This response is directed at the proponent's response to Council's and the Department's comment to MOD 3. The proposal is **not** supportable in its current form. It does not adequately address concerns raised by both the Department and Council, and does not comply with state SEPP policies as well as local area policies.

Following is commentary for MOD 3 (incorporating the undetermined Modification 2 where applicable) for 23 - 41 Lindfield Avenue, 7 and Lot 11 Havilah Lane Lindfield – updated following the approval of Modification 2 and commentary and additional information from Aqualand in respect of Ku-ring-gai's original commentary on Modification 3.

Drawing Title
ADAPTATION DETAIL PLANS

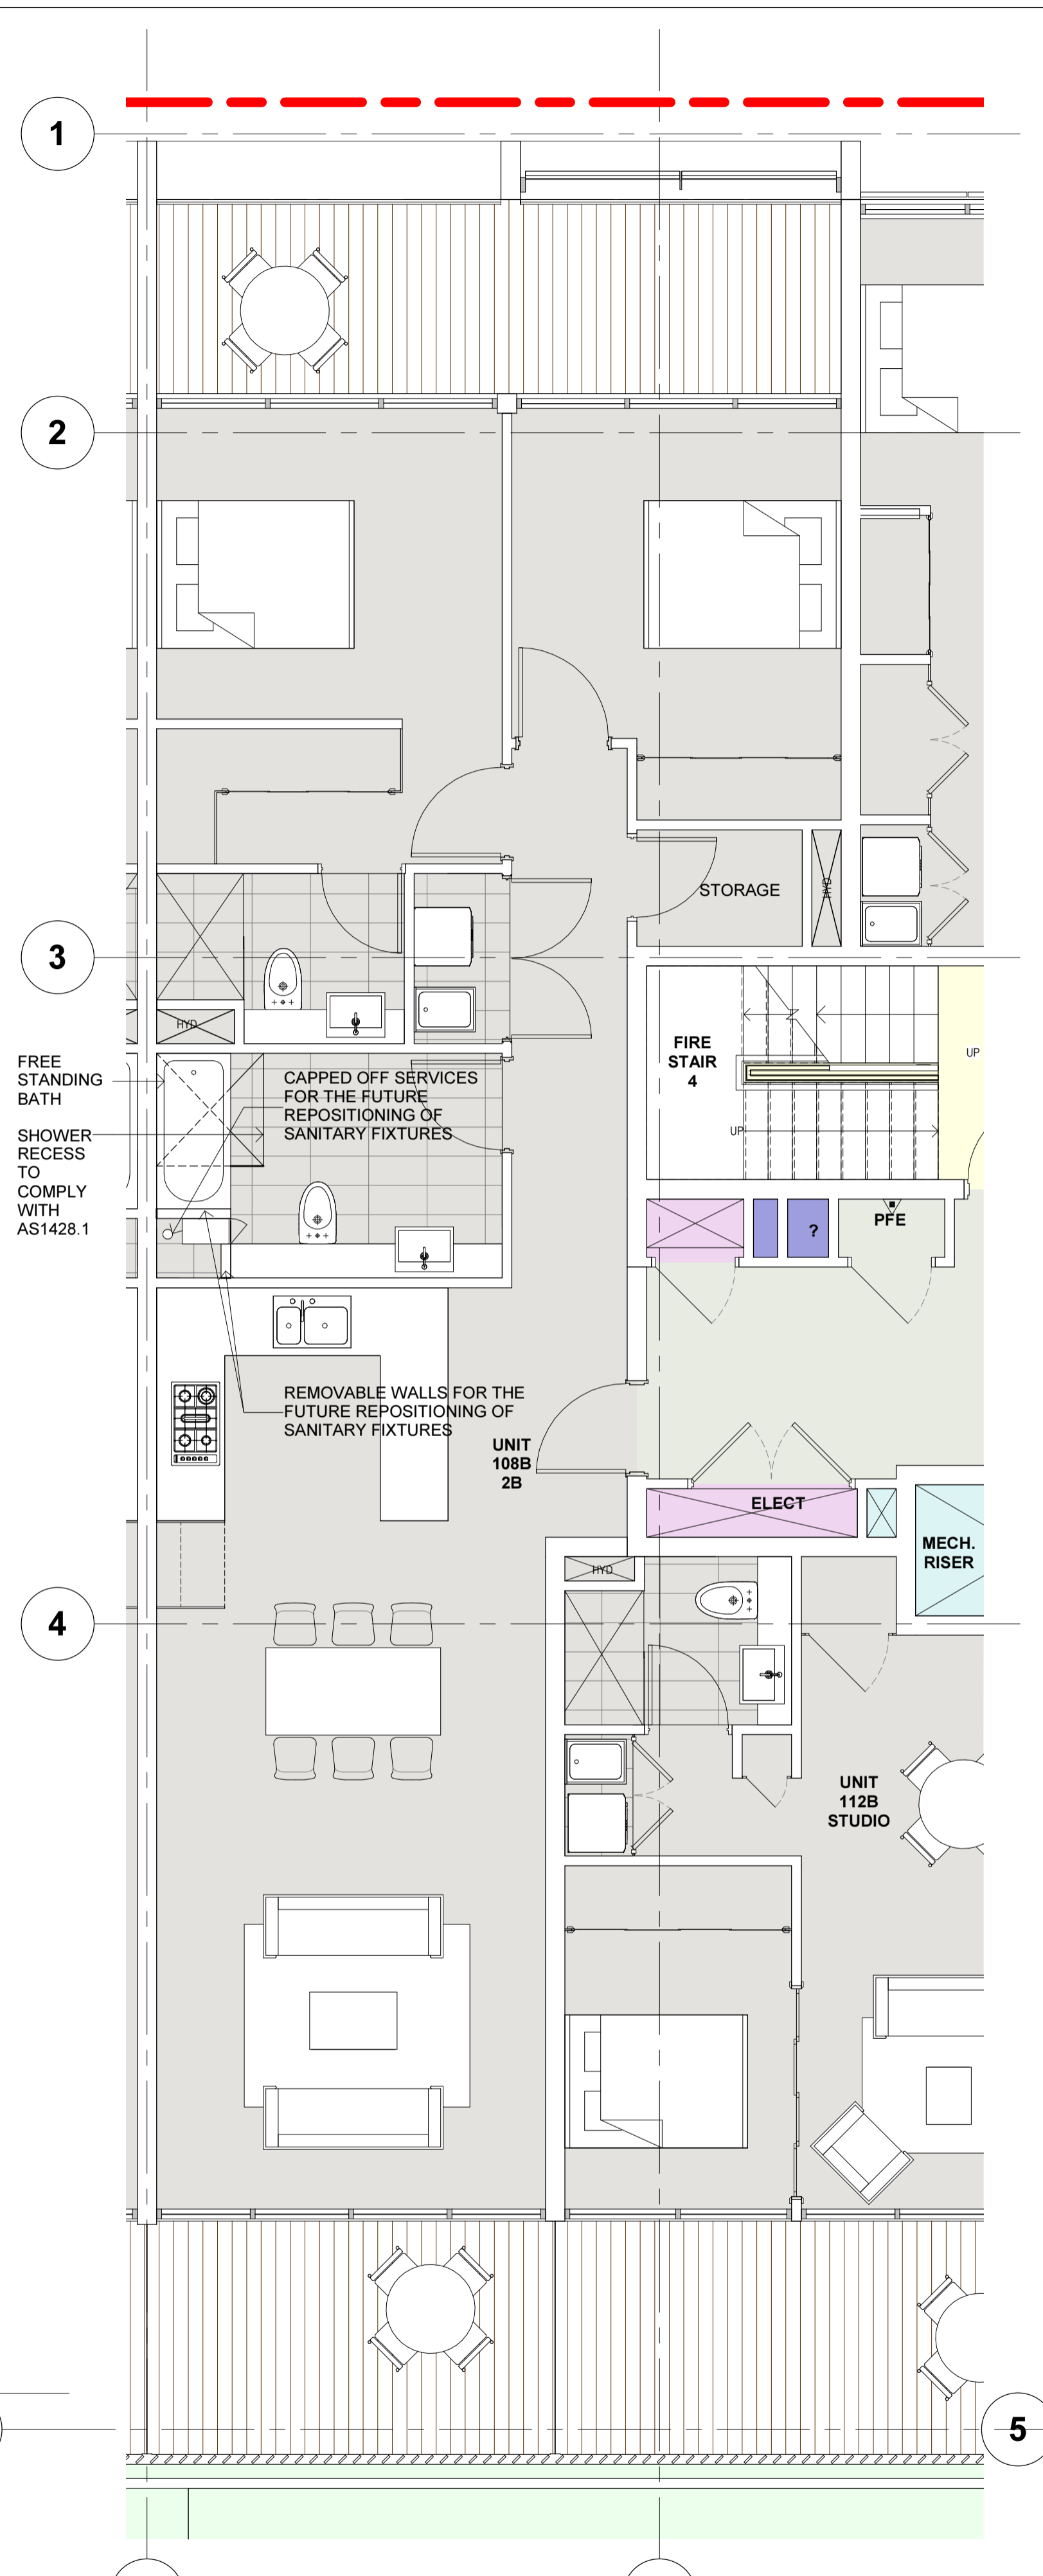
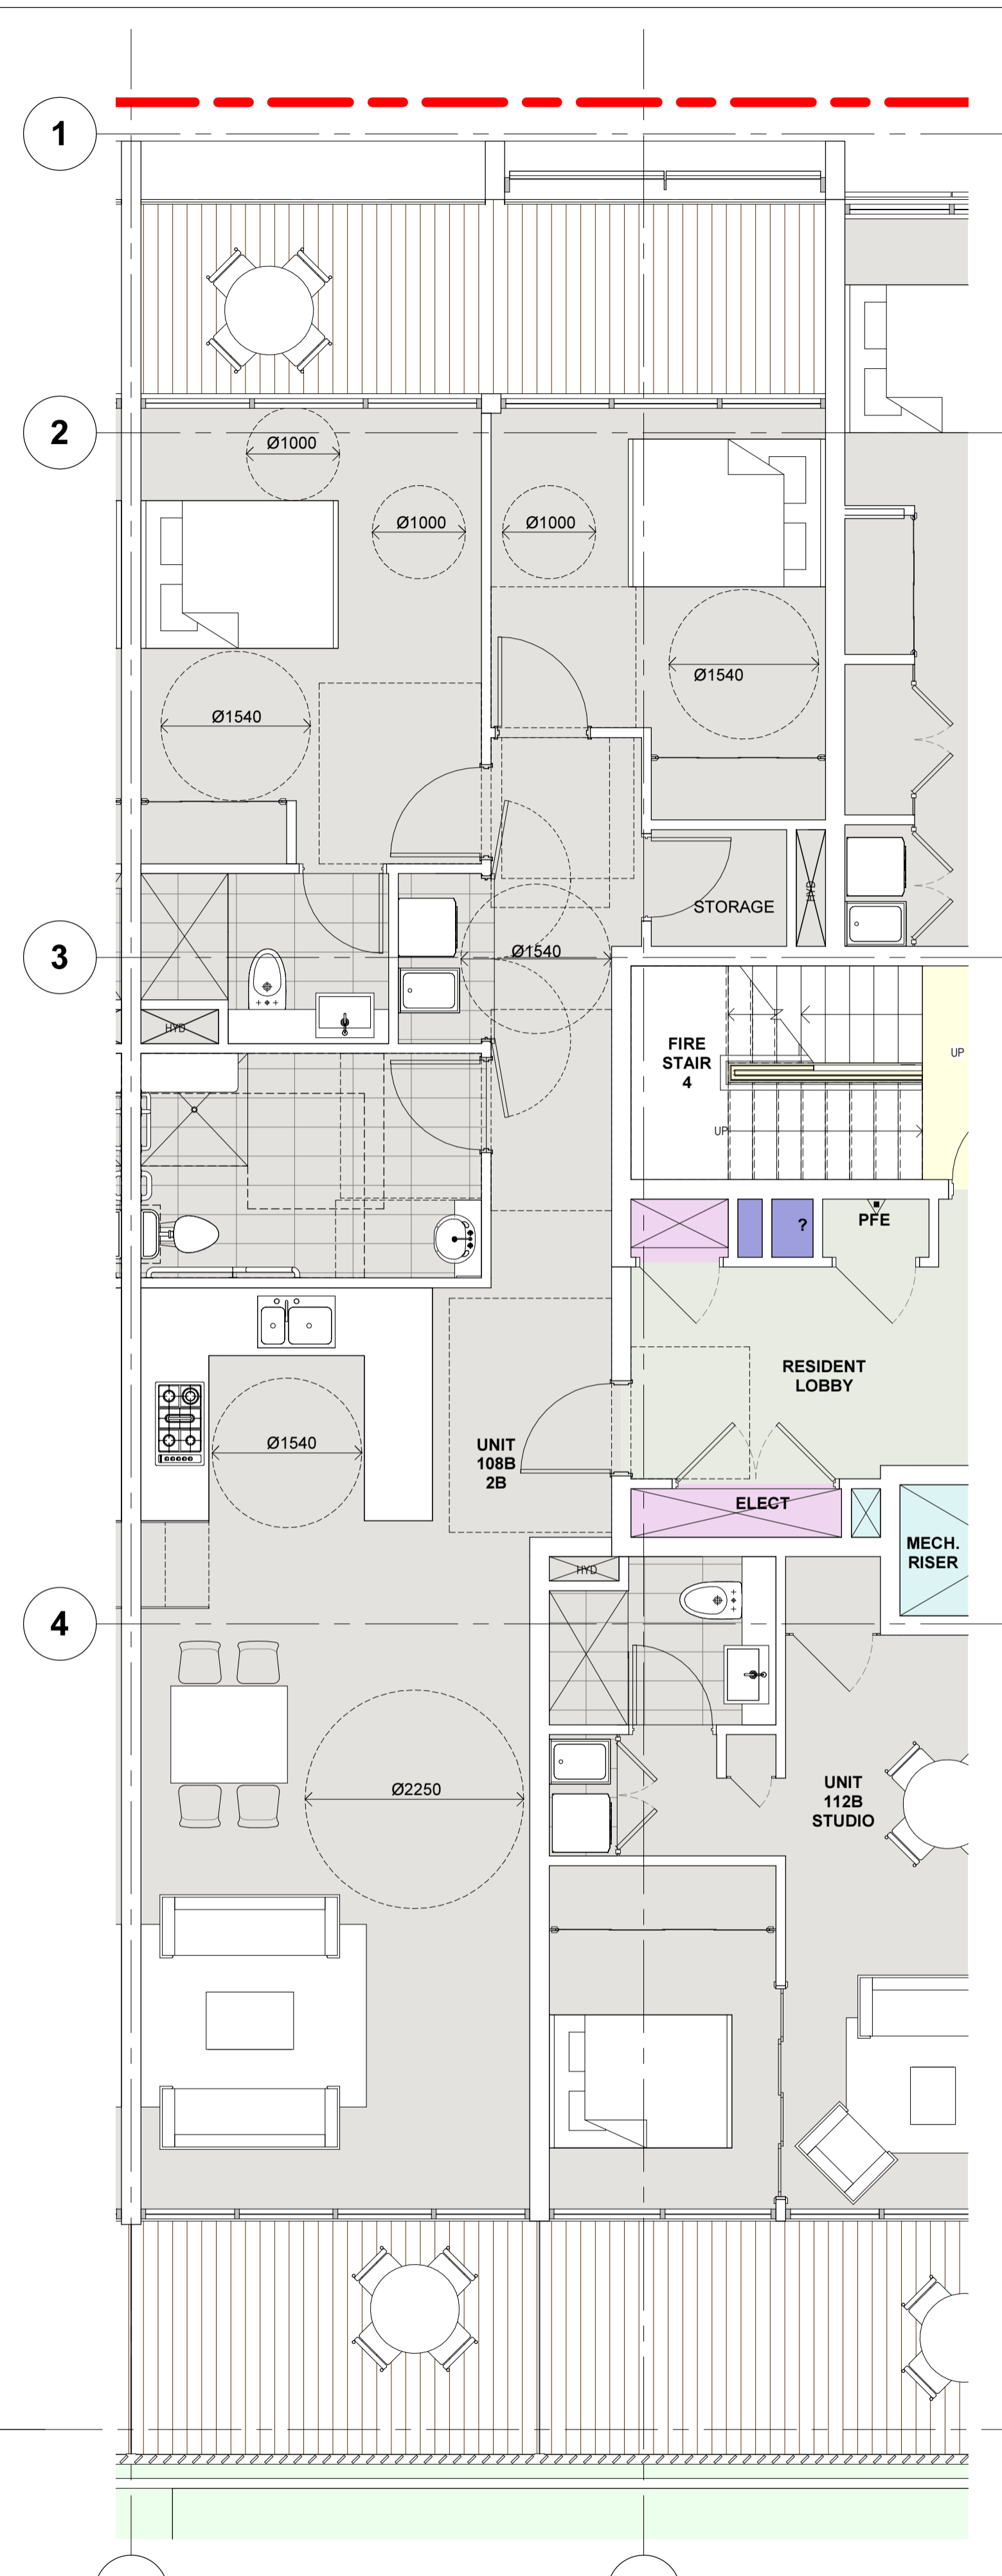
The revised architectural drawings show that the adaptable apartments are generally compliant with AS4299 (ADAZ6001H), however the clearance around the bed in the 1 bedroom type, and the laundry access in the 2 bedroom type (including the laundry door swings), should be verified.
